From: Brian Banister [REDACTED]
Sent: 09 December 2025 16:51
To: Planning.Responses <Planning.Responses@arun.gov.uk>
Subject: Arun Conservation Area Advisory Panel comments on applications

AB/142/25/HH - 59 Tarrant Street, Arundel
No Objection

ATTIC CONVERSION

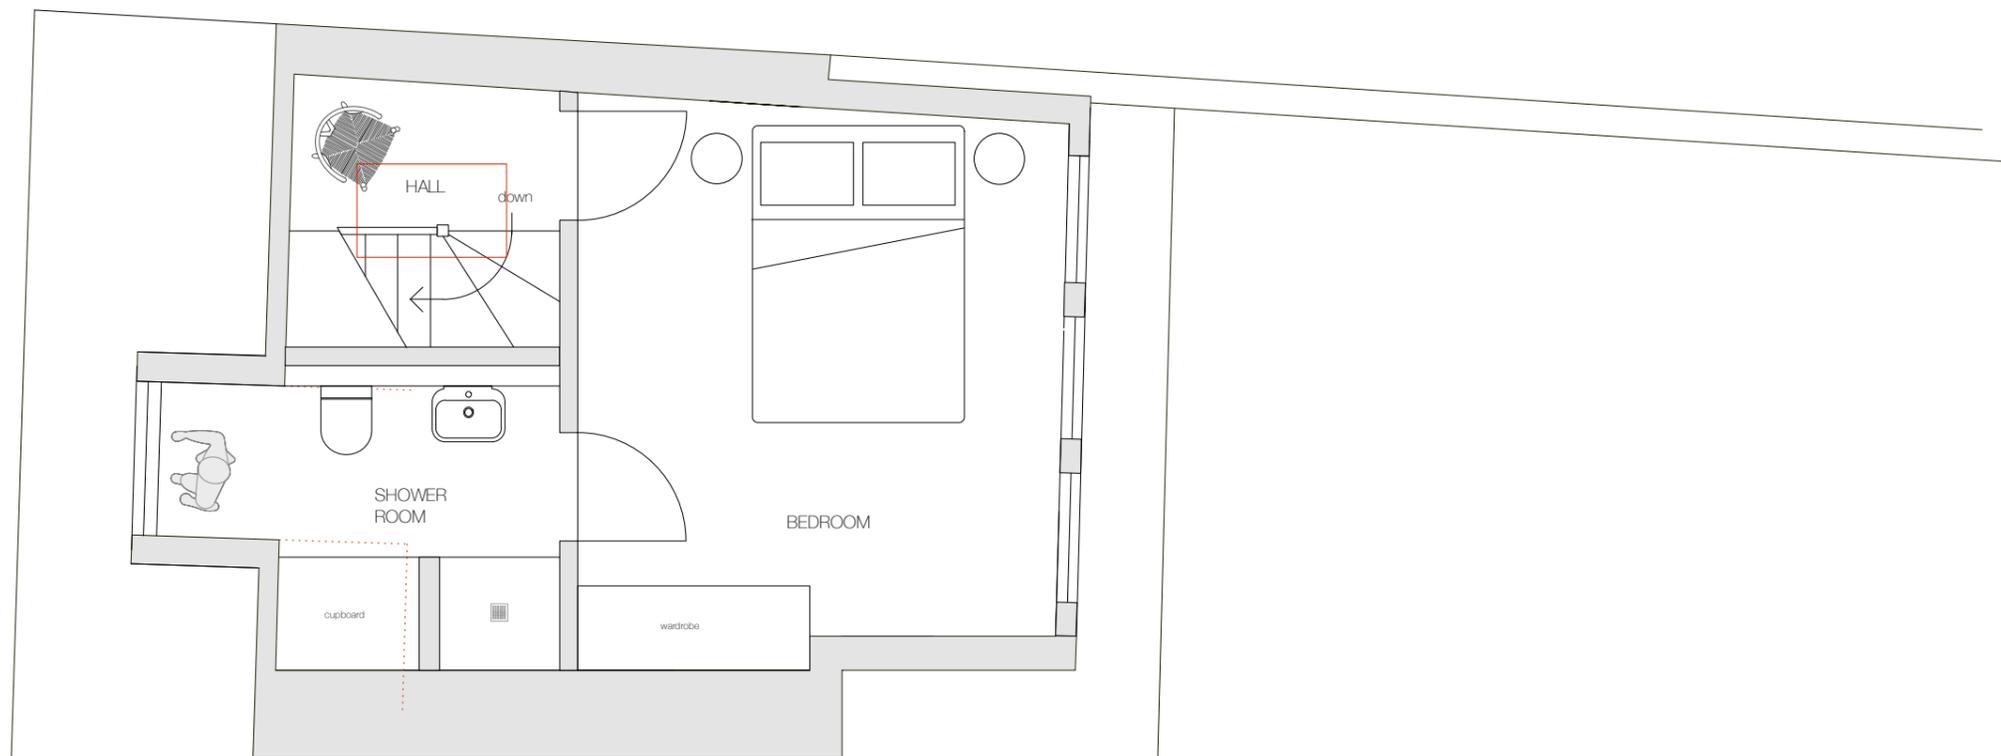
The property occupies a prominent position in Tarrant Street and is included in the Council's Local List. It is considered that the works will have a neutral impact on the character or appearance of the conservation area.
The Panel would normally object to overlarge dormer windows but, in this particular instance, the one proposed on the rear elevation of the property is unlikely to be viewed from public areas and there would be limited views from private ones. In addition, there is fine detailing and proportions to the fenestration, and good quality external materials are proposed.
